**Rezoning Transportation Analysis**  
**Petition Number: Insert Zoning Petition #2021-060**  
*General Location Identifier: 09509220*

Revision Log:	Date	Description
	05-27-2021	First Review (WB)
	08-23-2021	Second Review (WB)
	09-17-2021	Third Review (KP)
	10-27-2021	Fourth Review (PDM)

**RZ-1.0**

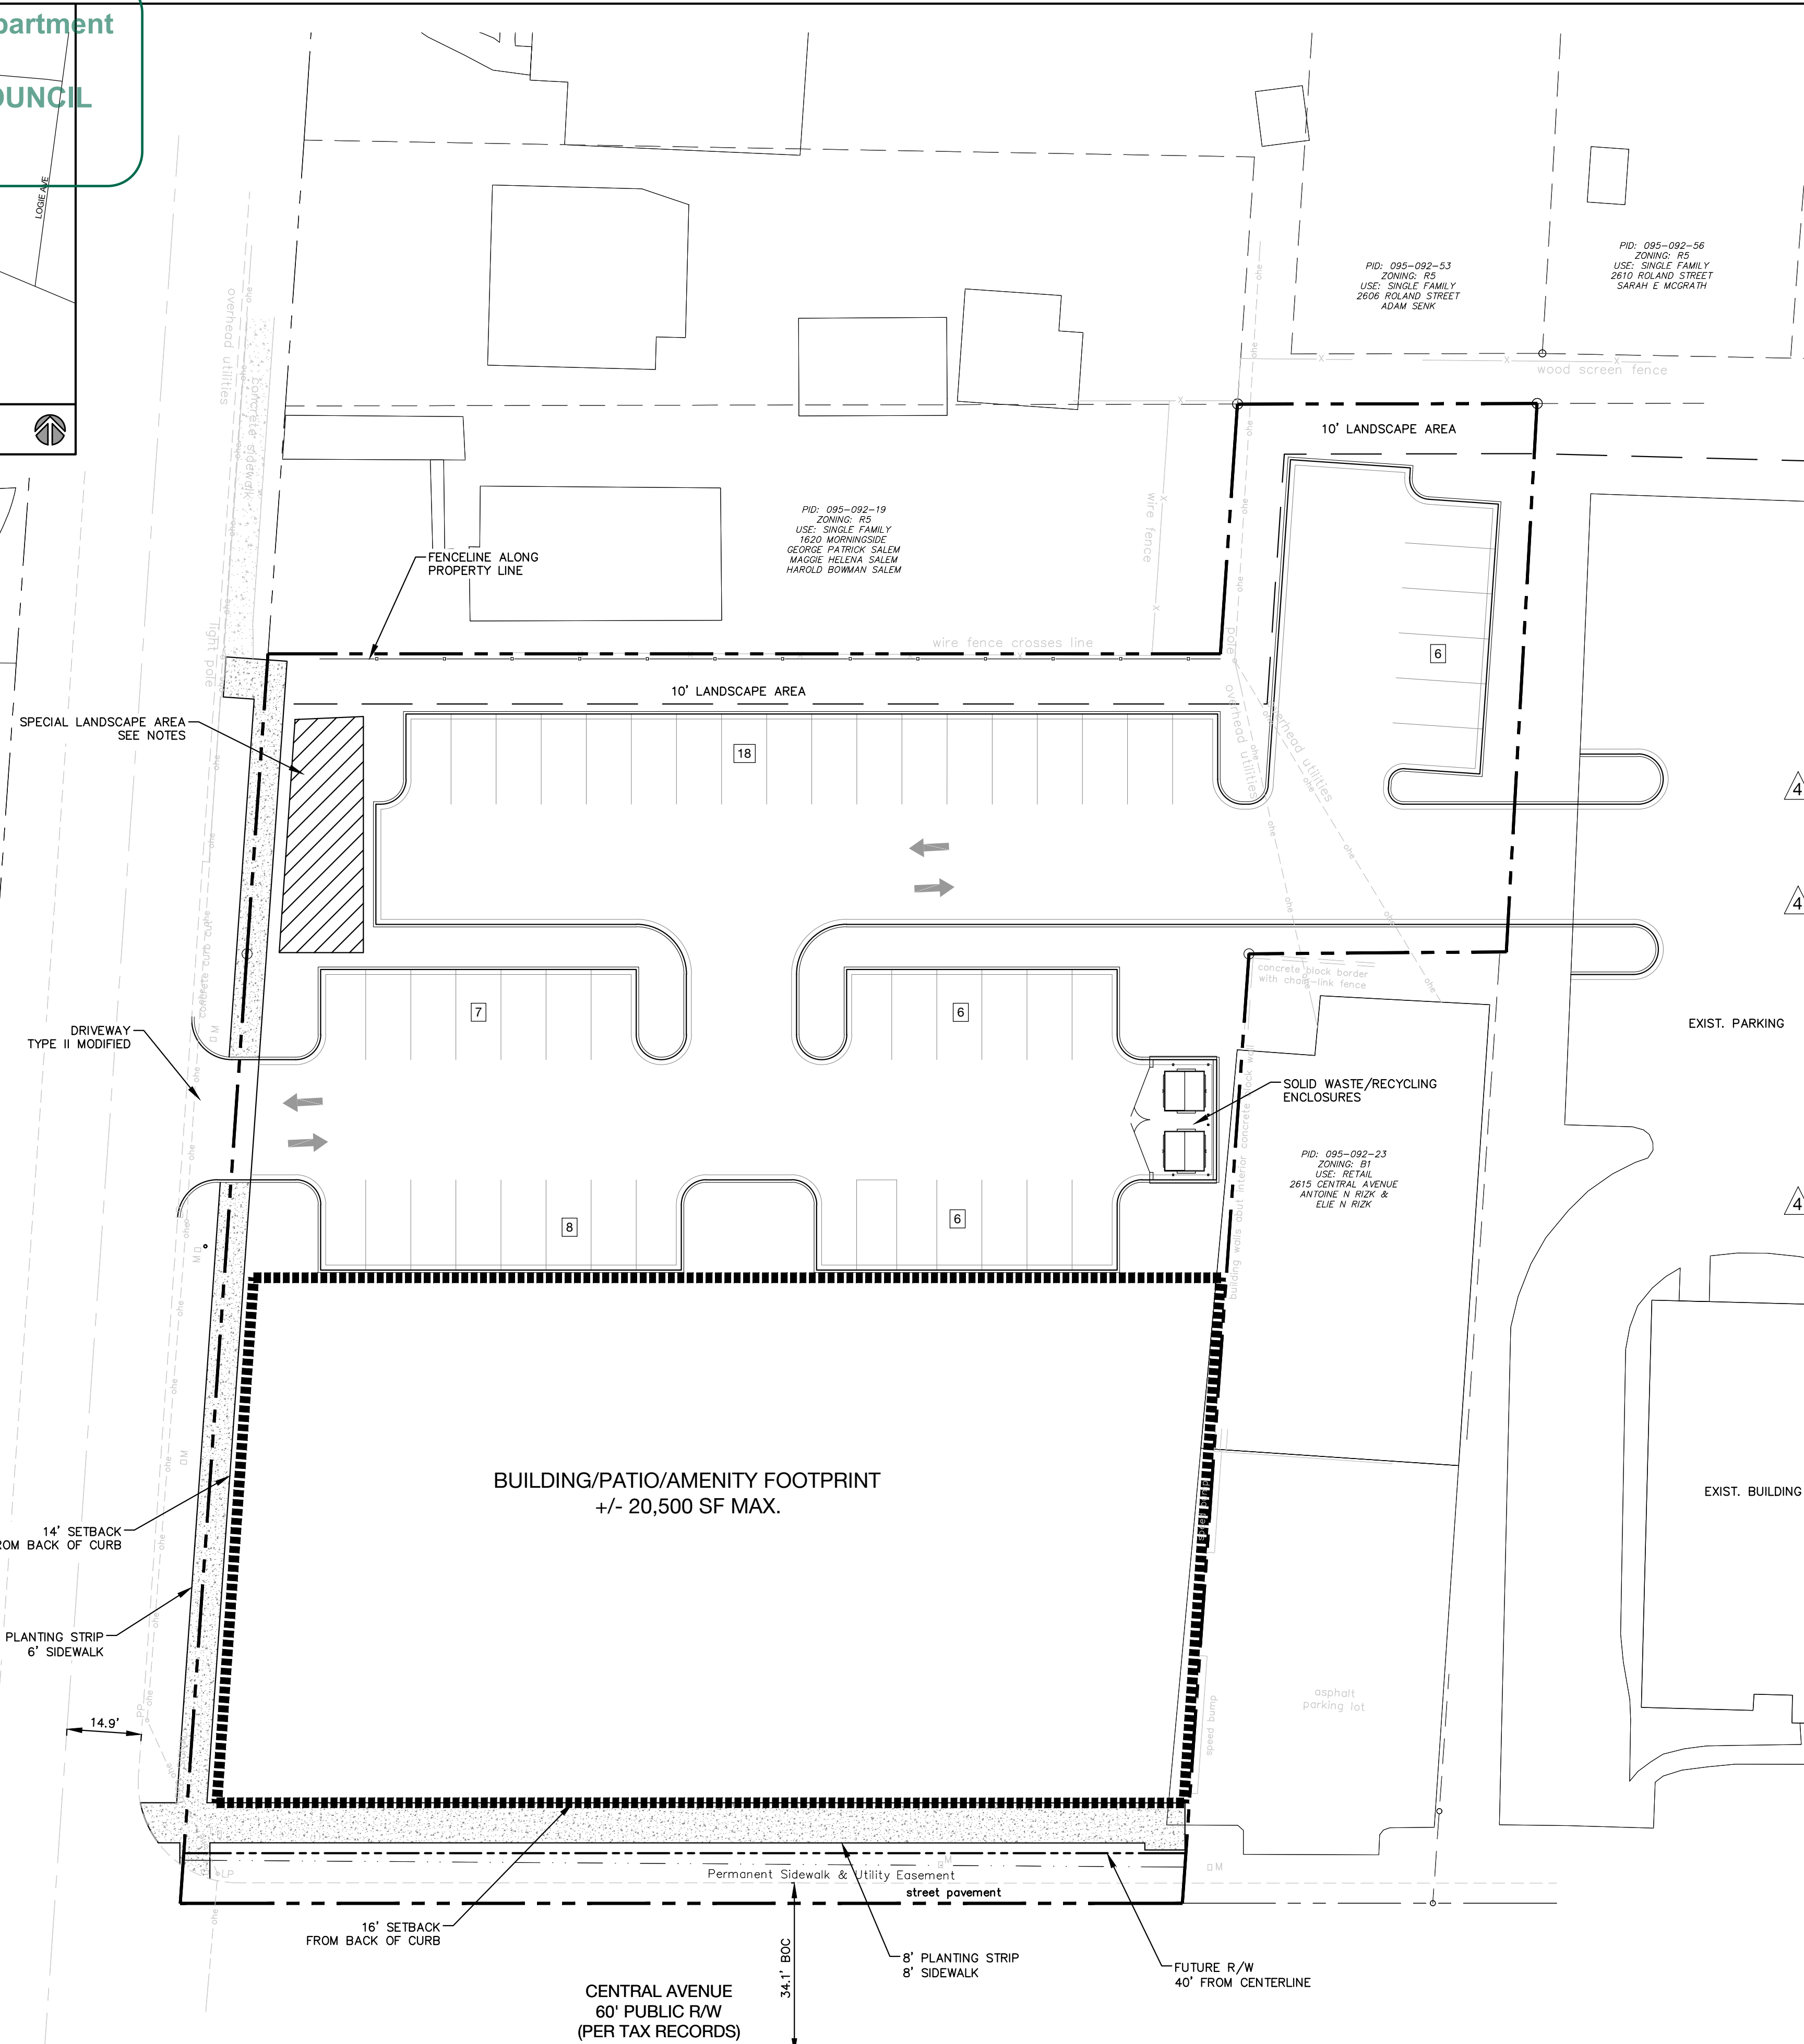
Label and dimension the curb and gutter from the centerline for each road on the site plan.
2. **Traffic Study:**  
~~A Traffic Impact Study (TIS) is not necessary for the complete review of this petition due to the site generating less than 2,500 daily trips. If during the permitting process the site generates more than 2,500 daily trips, then a traffic study will be required.~~

4. **OUTSTANDING COMMENT (08.23.2021)** ~~Modify the conditional notes, by including a note regarding dedication and fee simple conveyance of all rights-of-way to the City before the site's first building certificate of occupancy is issued. CDOT requests rights-of-way set at 2' behind back of sidewalk where feasible.~~

**Conditional Note D under Streetscape and Landscaping needs to include dedication and fee simple conveyance of all rights-of-way to the City before the site's first certificate of occupancy is issued need.**
